A12 Chelmsford to A120 widening scheme

TR010060

9.32 Applicant's Comments on Responses to ExQ1

Applicant's Comments on Responses to ExQ1

FIGURE 6.1

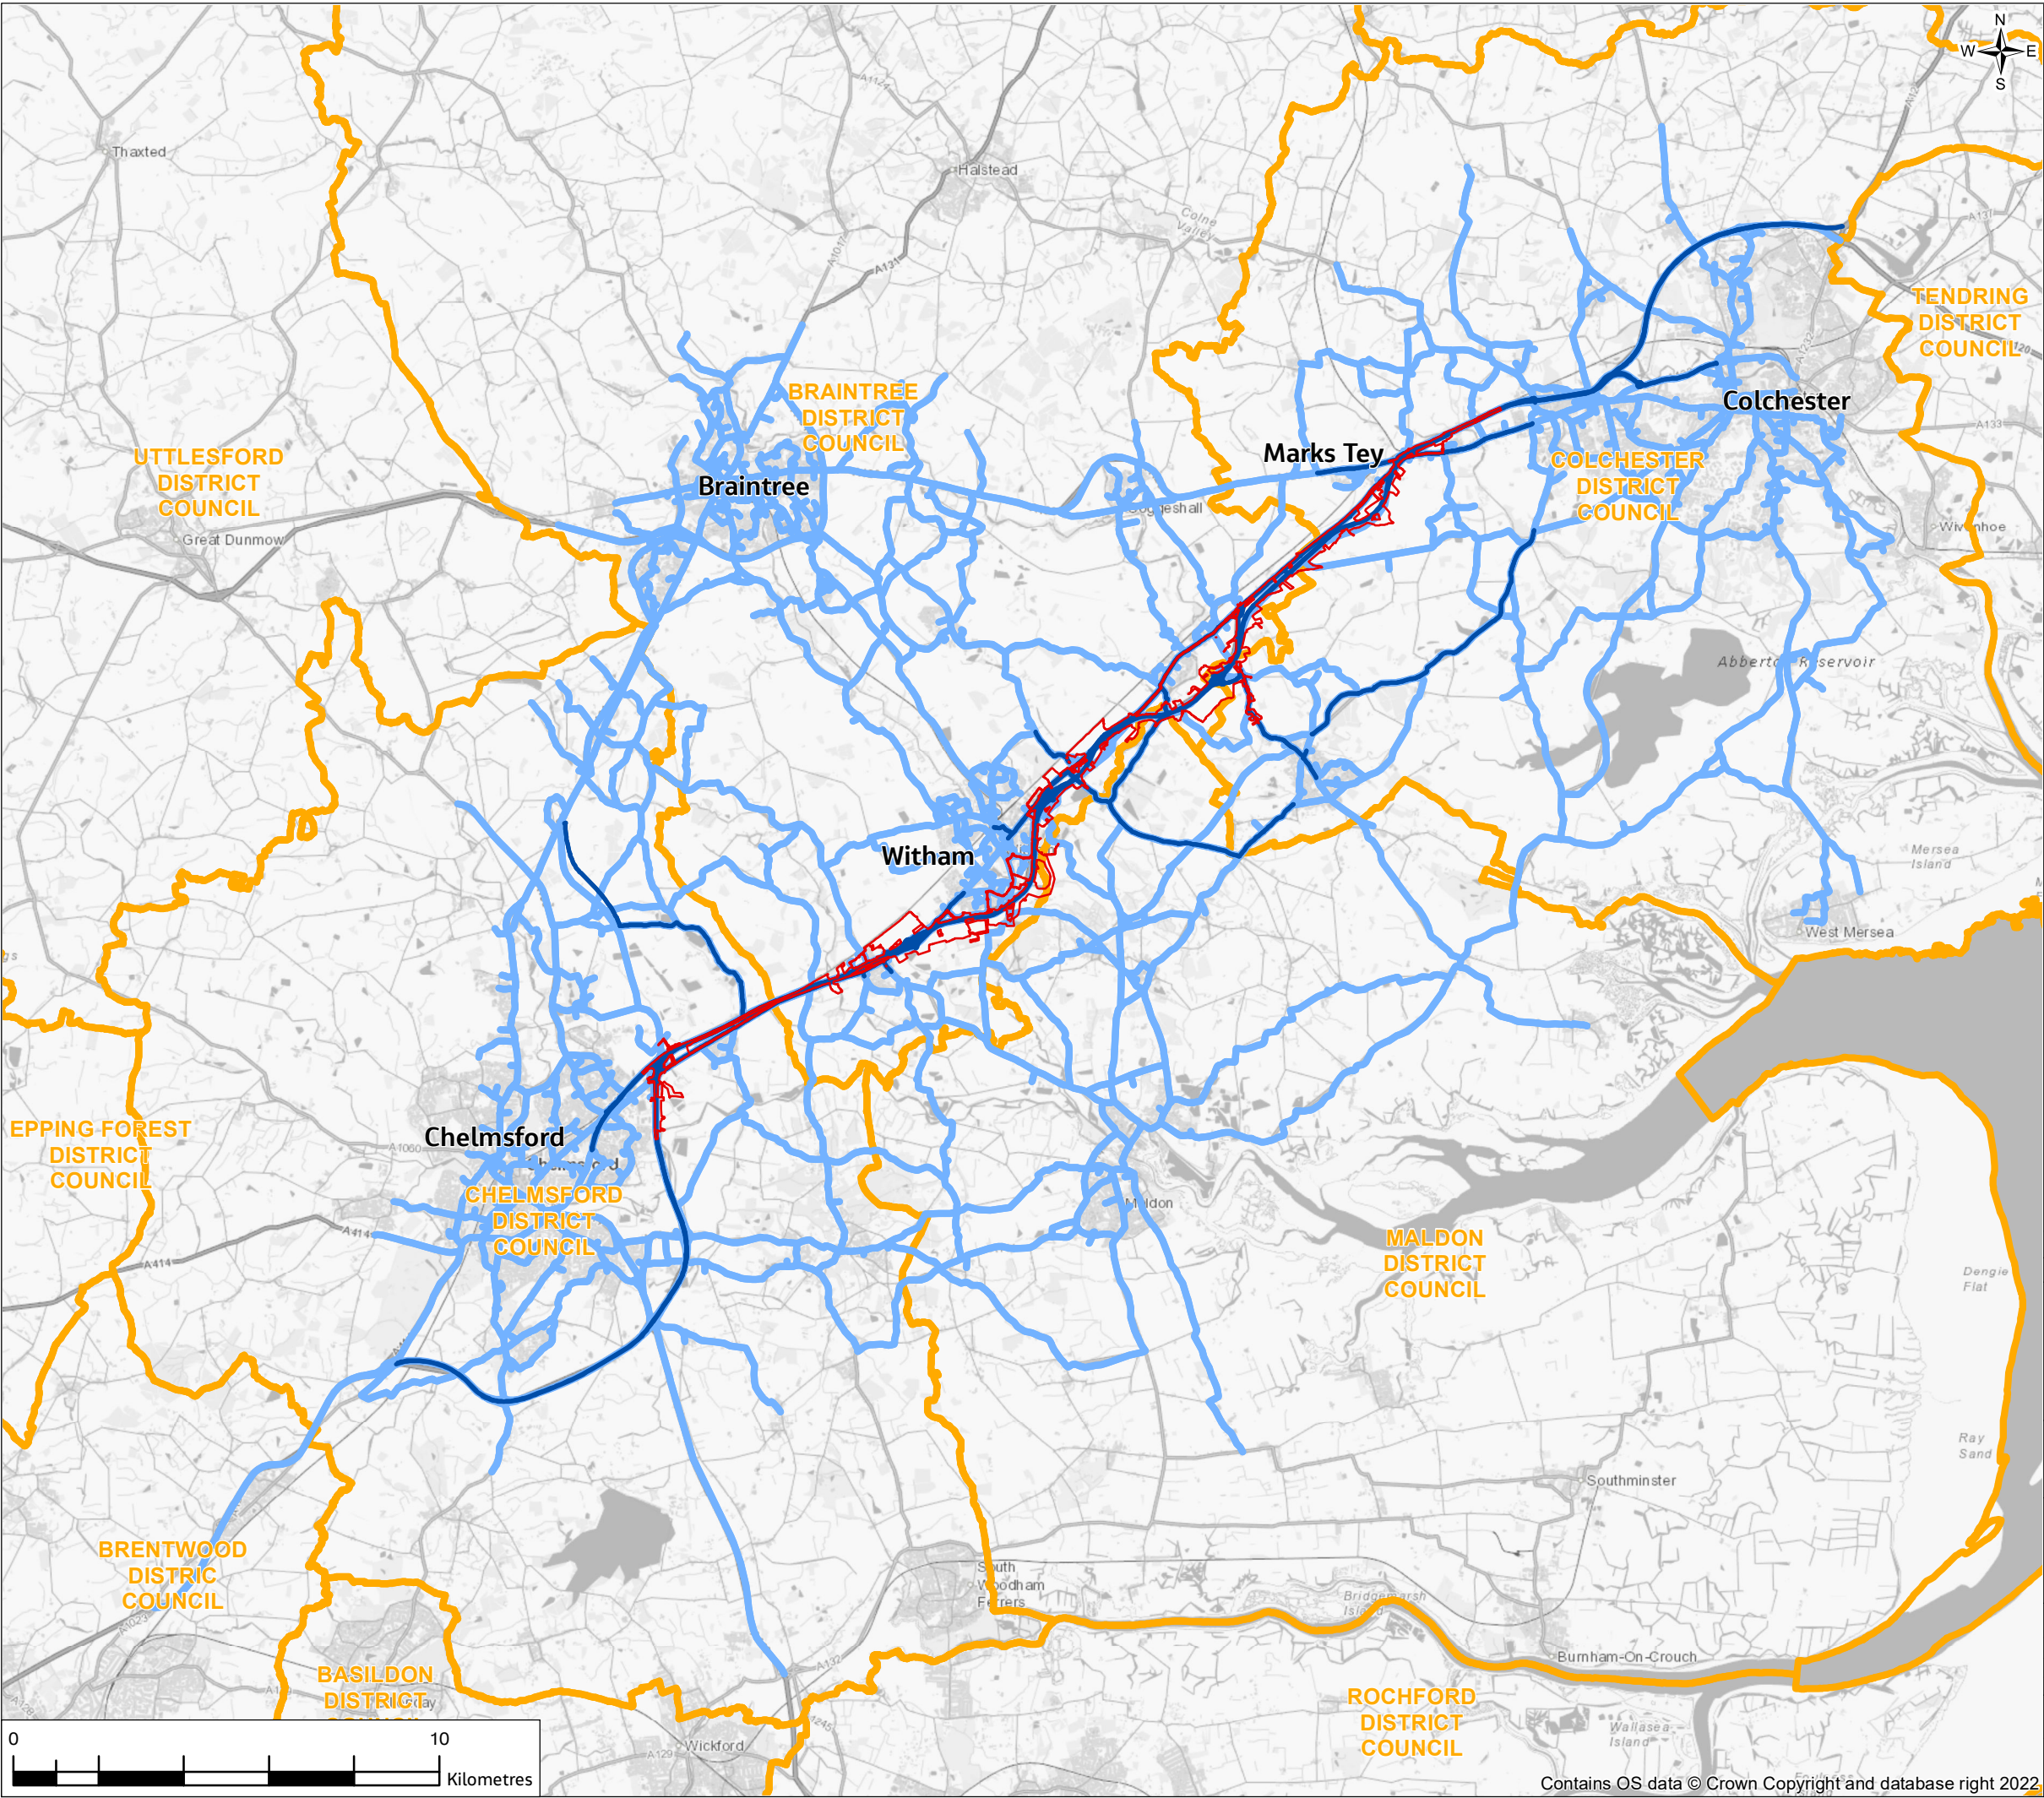
Figure 6.9 identifies modelled receptors points along the A120 (R162, R163, R165, R166 and R168). However, Figure 6.9 and Chapter 6 Air Quality neglect to provide modelled concentrations either in tabular or graphical representation for the base 2019, do minimum or do something scenarios. It is not clear what local features have been input for these locations: For R162 & R163 it is reasonable to consider the use of a partial street canyon within the model which could affect modelled outcomes significantly. With this fundamental information missing, CoCC cannot determine that air quality in Marks Tey will not be affected.

construction scenario. The Applicant would draw attention to Figure 6.1 [APP-205] which presents a combined ARN for construction and operational scenarios. The construction ARN is confined to the junction with the A12 whereas the ARN extends to Ashbury Drive for the operational scenario. Figure 6.1 [APP-205] has incorrectly presented the ARN extending to Great Tey Road, where as it should extend to Ashbury Drive. In response to comments made at consultation events the air quality study area was extended along the Coggeshall Road (A120) which include receptors R162 and R163 and monitoring locations R136 and R137
